CITY OF PORTLAND, MAINE

June 14, 2016

Project Name:	Waynflete School Campus Upgrades	Project ID:	2015-034
Address:	360 Spring Street	CBL:	061-4-4
Applicant:	The Waynflete School	Planner:	Nell Donaldson

Waynflete School Campus Upgrade Project
Level III Site Plan Review
2016-034
The Waynflete School

A1 SITE PHOTOMETRIC PLAN
SCALE: 1"=20'-0"

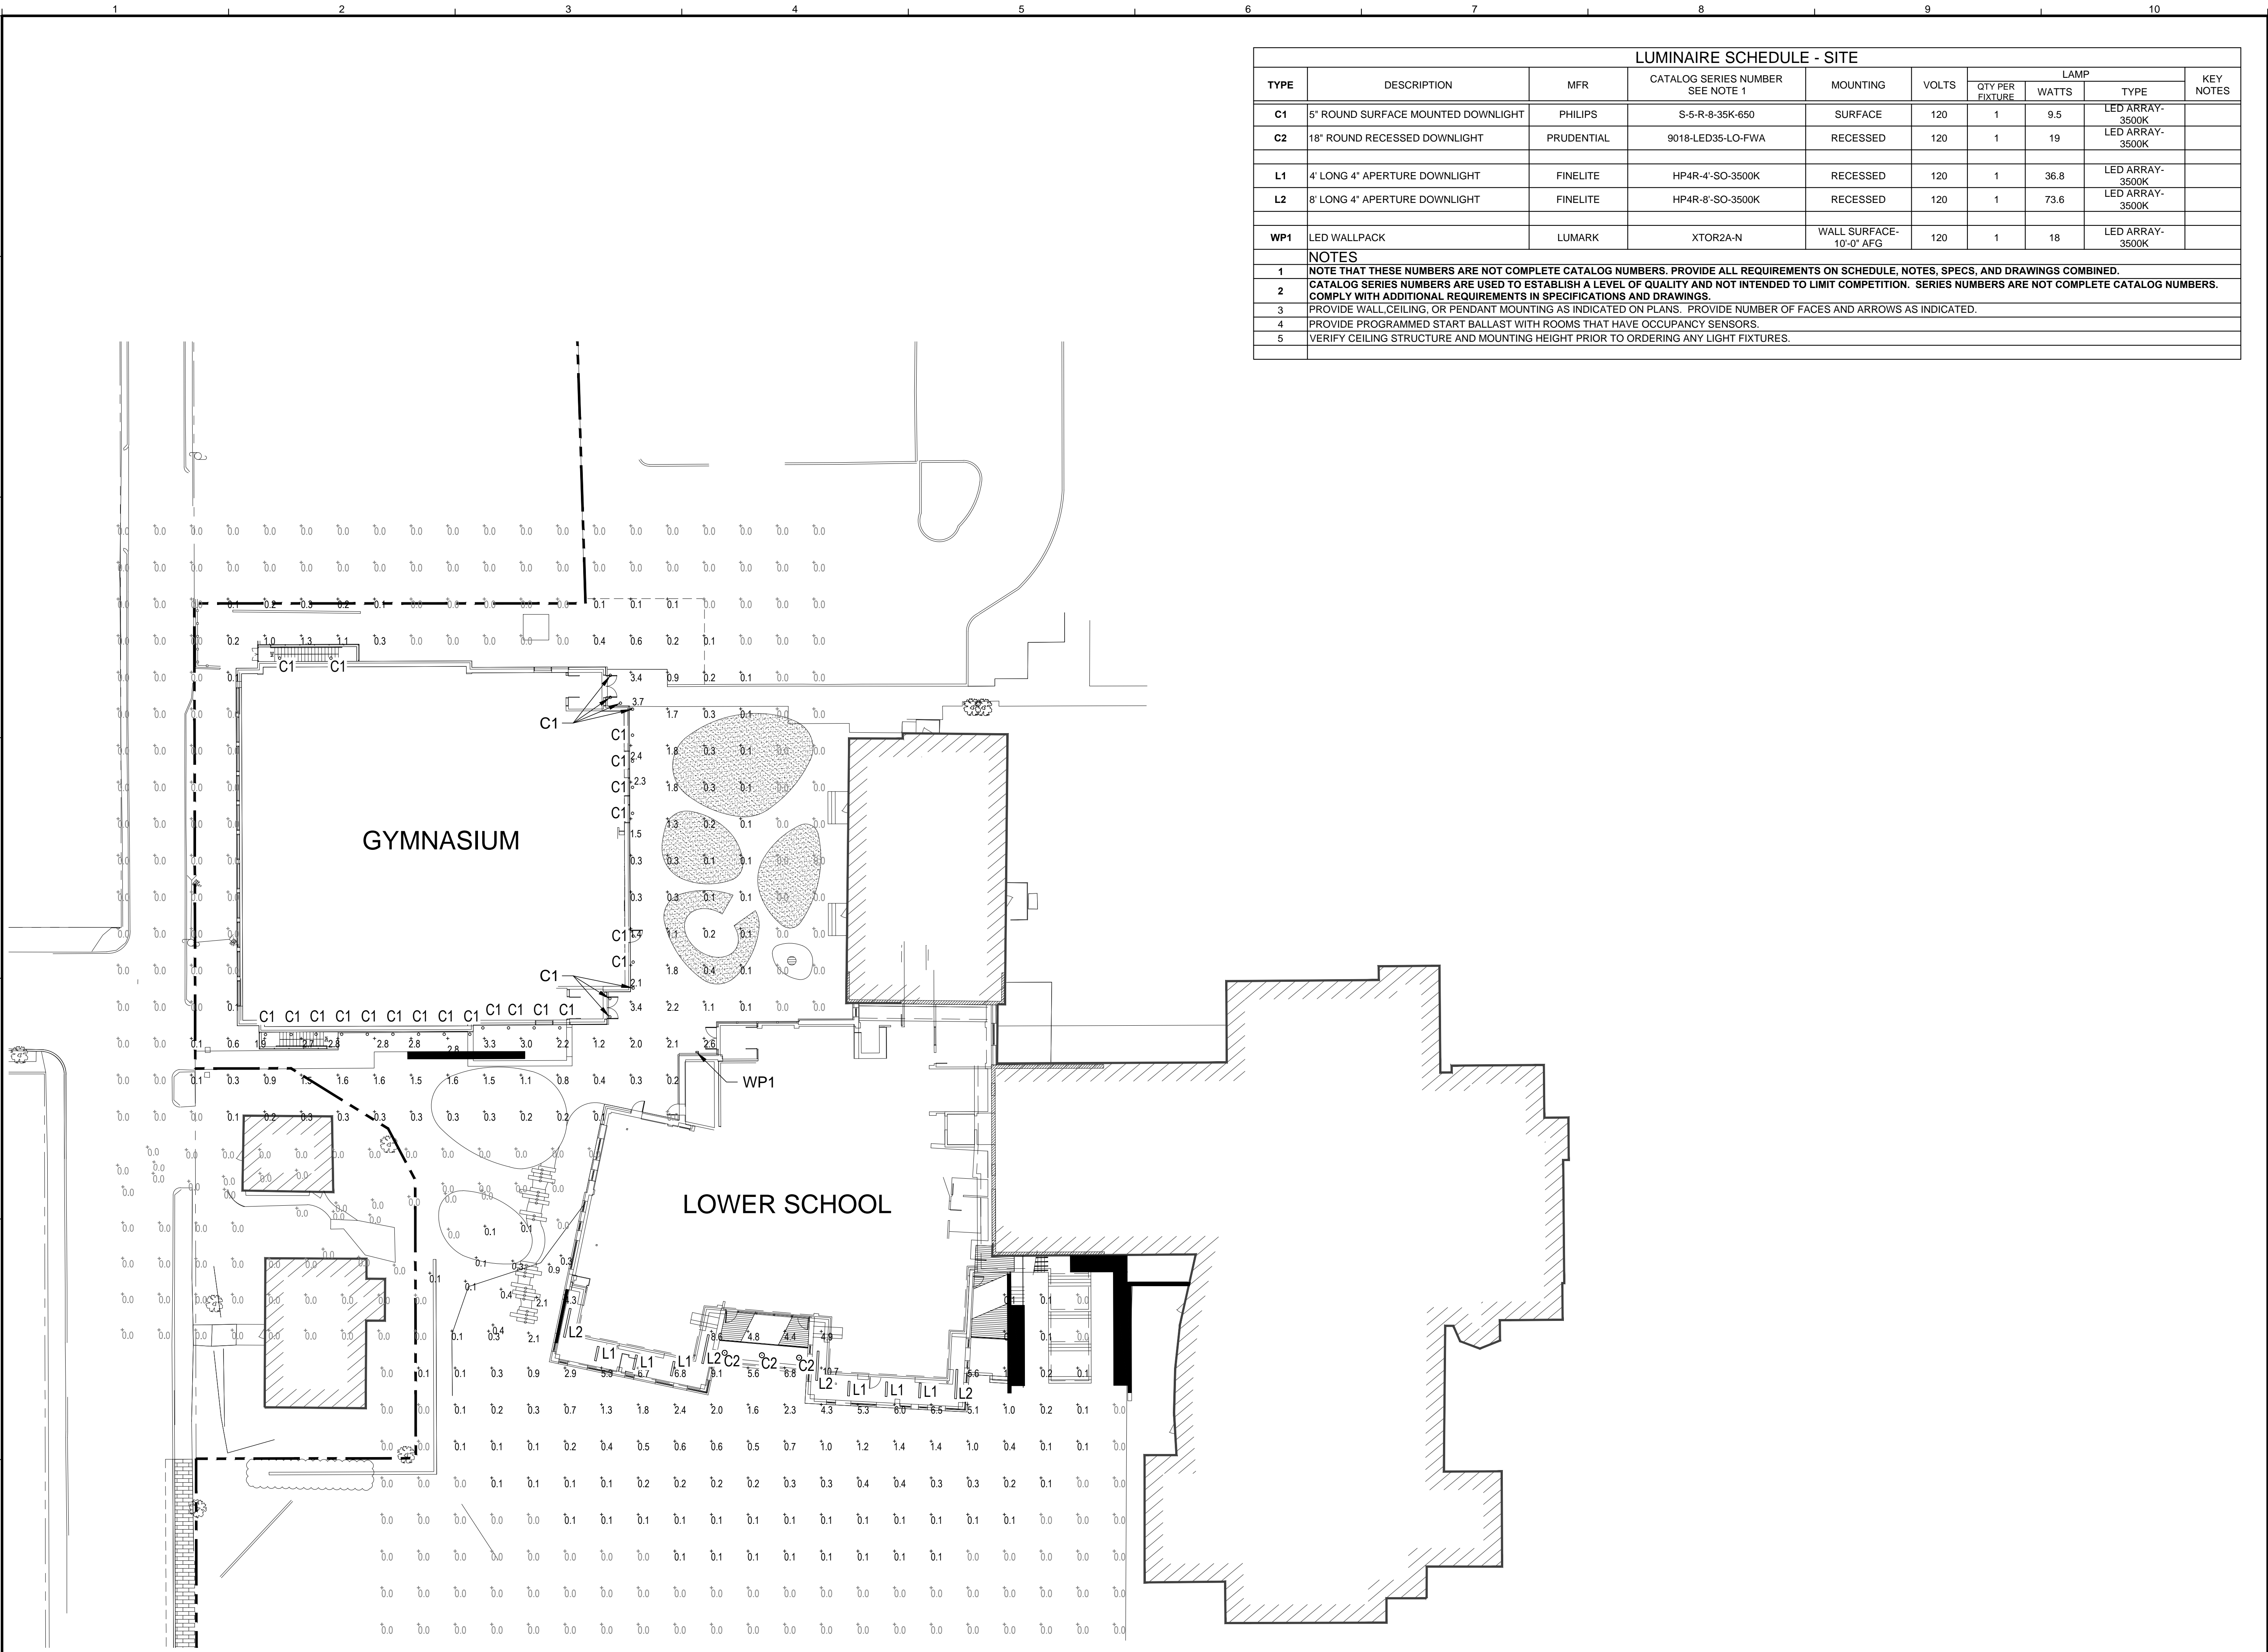
The Planning Board voted 5-0 (Morrissette and Boepple absent) to find that extraordinary conditions exist or undue hardship may result from strict compliance with the *Technical Manual* standard (*Section 12.2.3*) which establishes a maximum illumination level of 5.0 footcandles, that substantial justice and the public interest are secured with the proposed variation in this standard, and that the variation is consistent with the intent of the ordinance. The Planning Board waived the *Technical Manual* standard (*Section 12.2.3*) to allow a maximum illumination level of 5.1 footcandles.

The Planning Board voted 5-0 (Morrissette and Boepple absent) to find, based upon the planning staff's review, that extraordinary conditions exist or undue hardship may result from strict compliance with the *Technical Manual* standard (*Section 12.2.5*) which establishes a maximum illumination level at the property line of 0.1 footcandle, that substantial justice and the public interest are secured with the proposed variation in this standard, and that the variation is consistent with the intent of the ordinance. The Planning Board waives/does not waive the *Technical Manual* standard (*Section 12.2.5*) to allow a maximum illumination level of .4 footcandle immediately south of the proposed gym.
